Application No: H01/0185/96 Date Received: 28-FEB-96

Description of Original Development: Demolition of existing dwelling and erection of replacement dwelling

Location: Land Off Mill Drove, Cowbit

Amendment Submitted: Bungalow re-positioned 7.5m towards Mill Drove

PROPOSED BUNGALOW AT : MILL DROVE , COWBIT , SPALDING. FOR : MR & MRS R.W. BRADSHAW

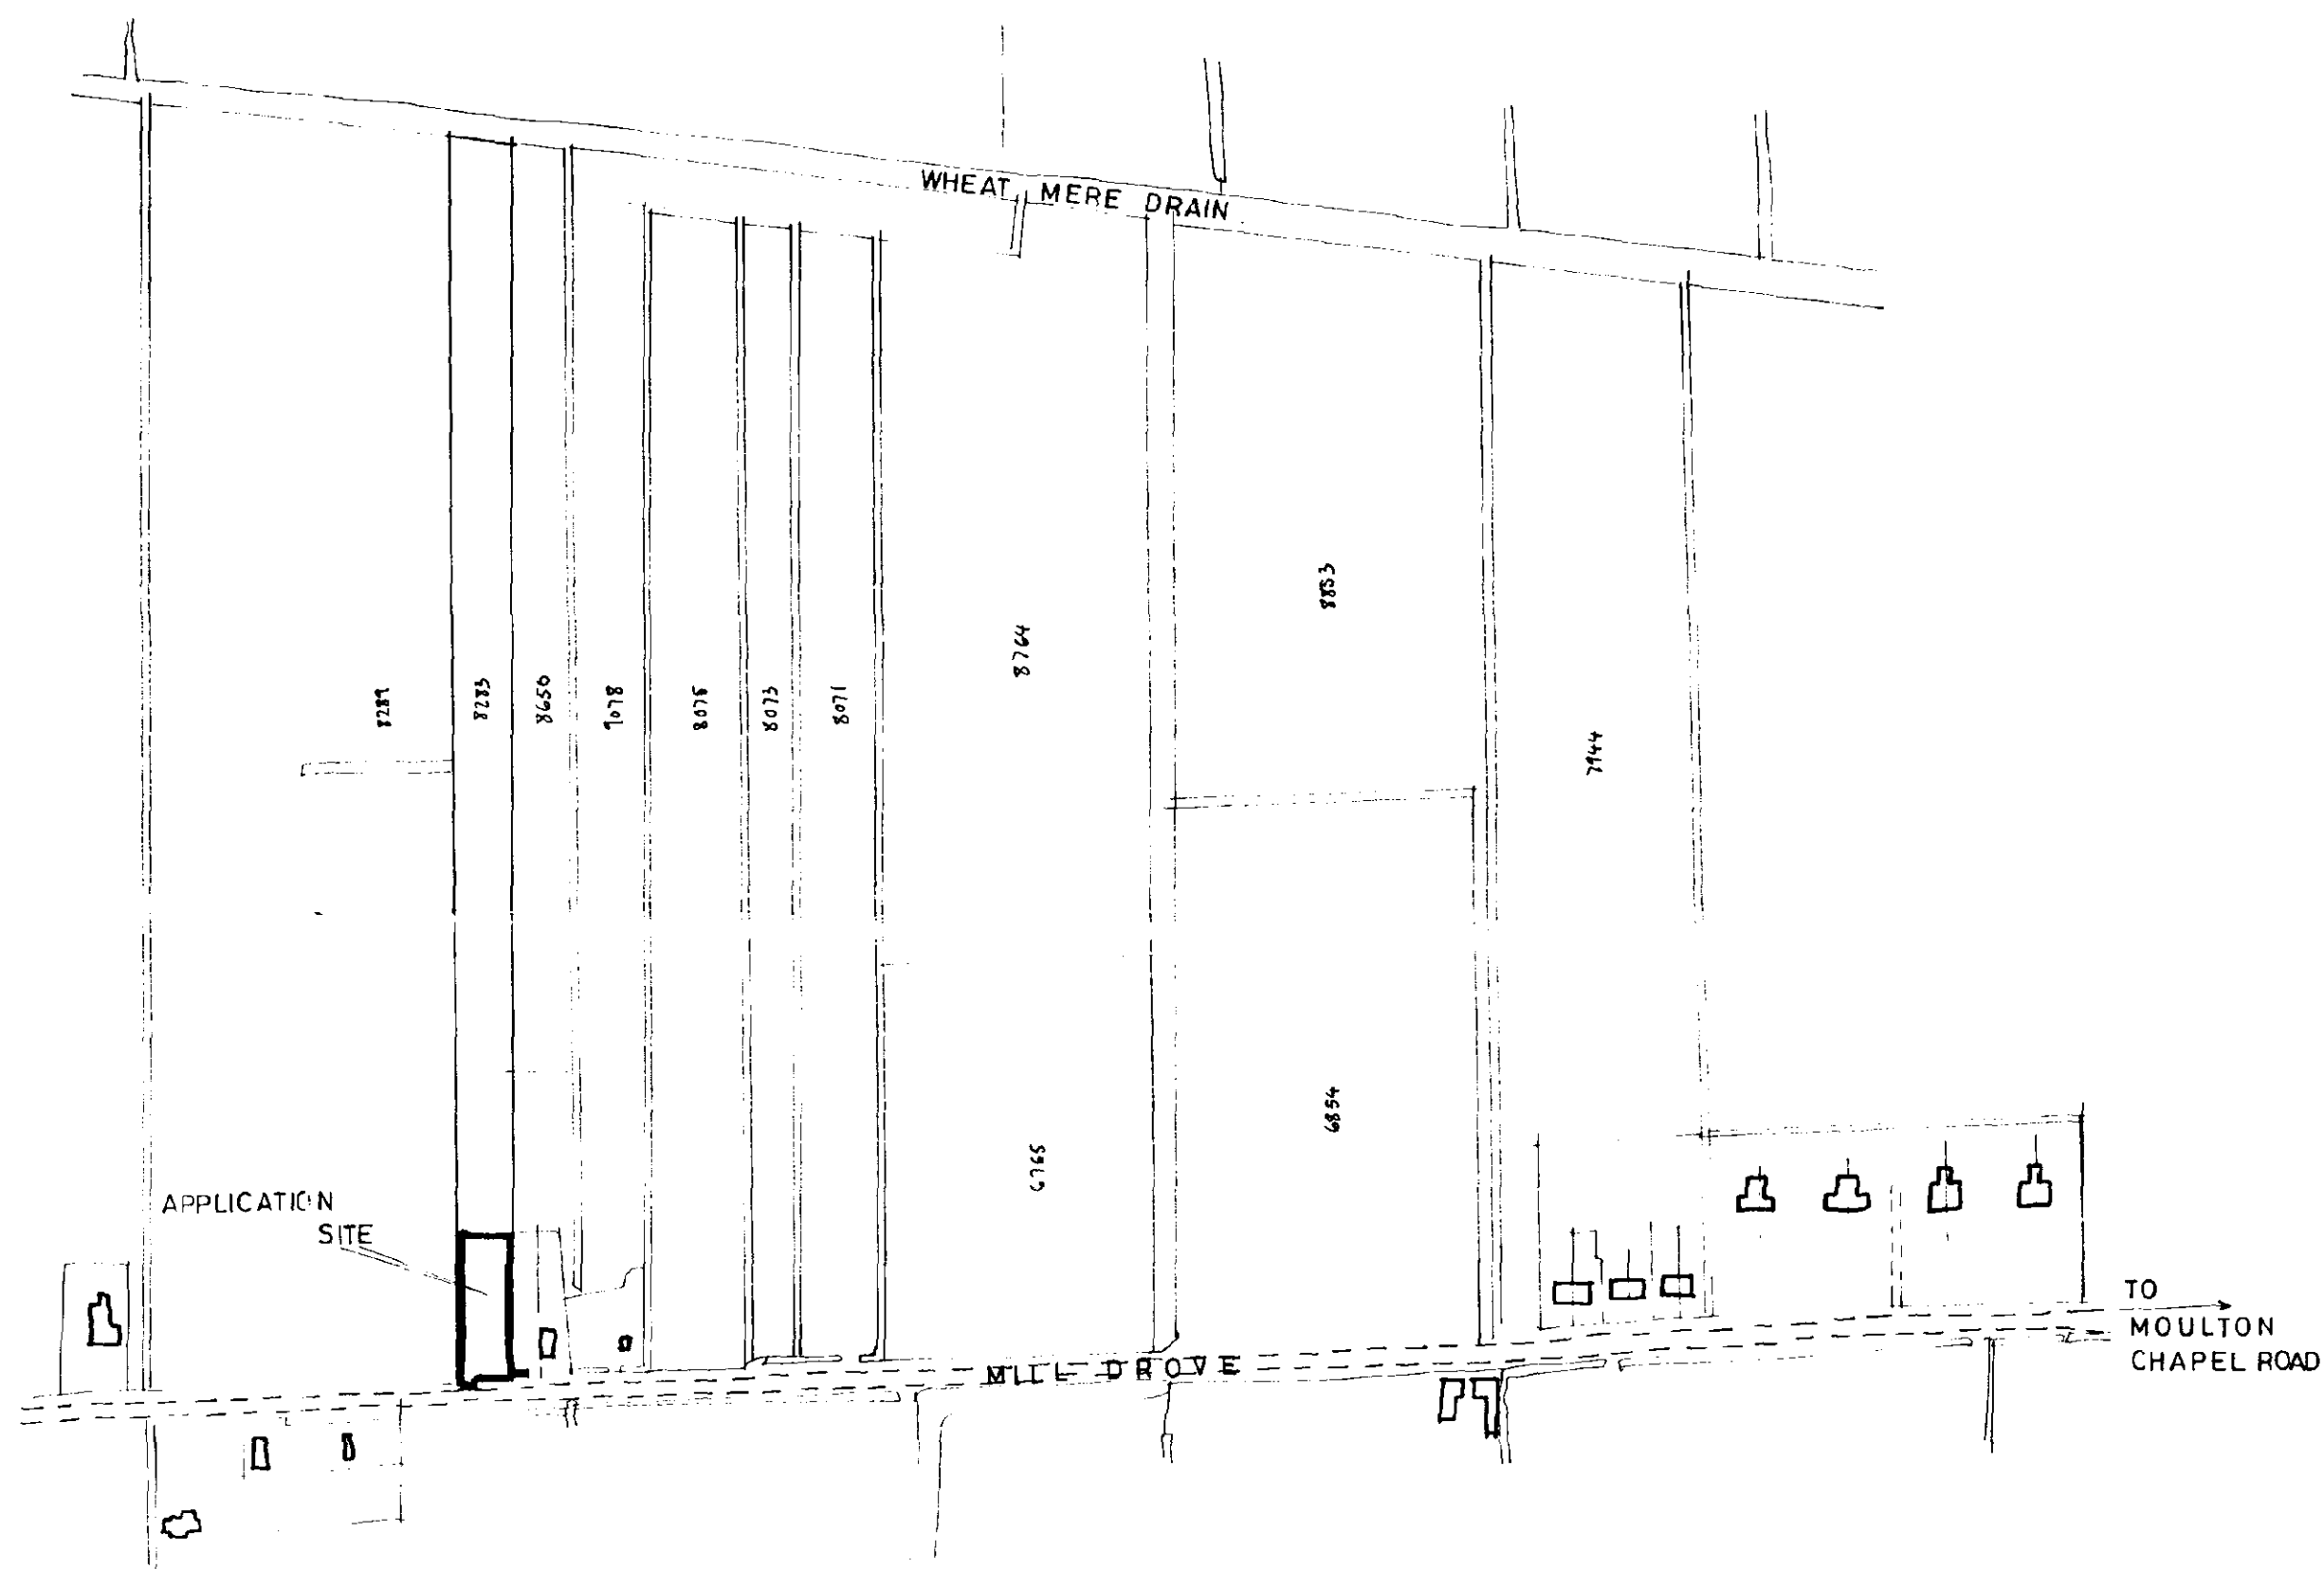
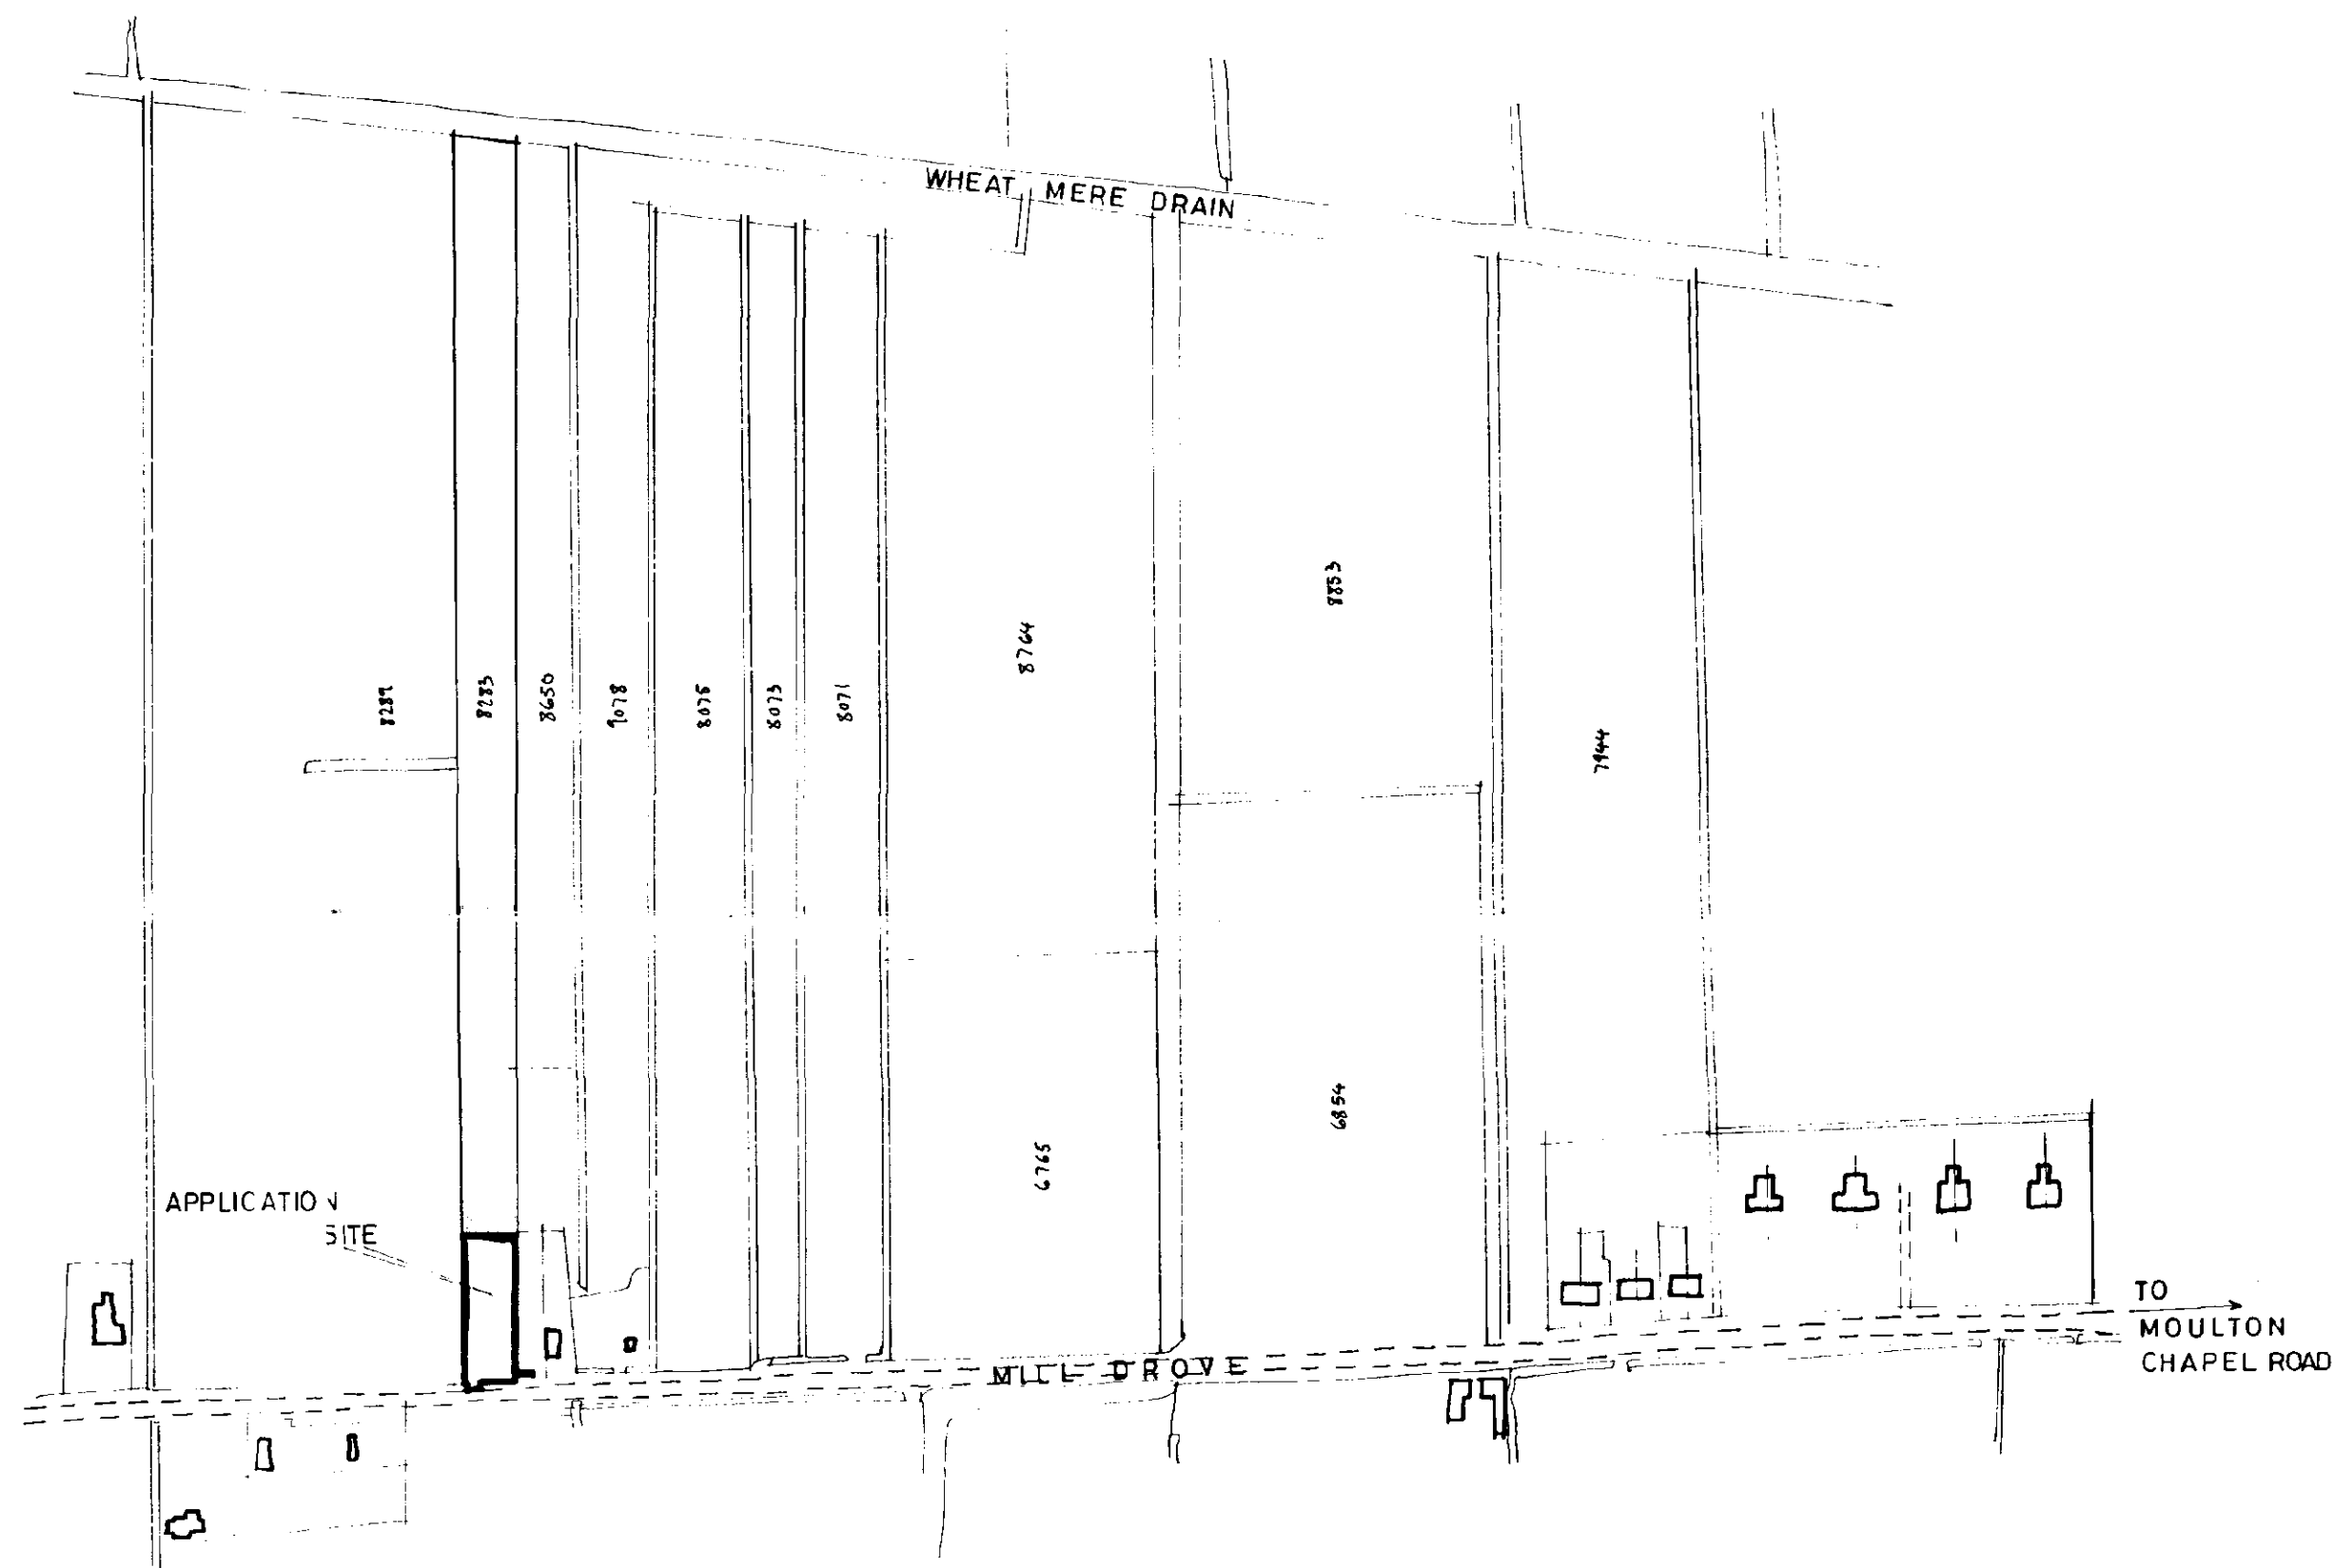
BUNGALOW REPOSITIONED 7.5m
 TOWARDS MILL DROVE.
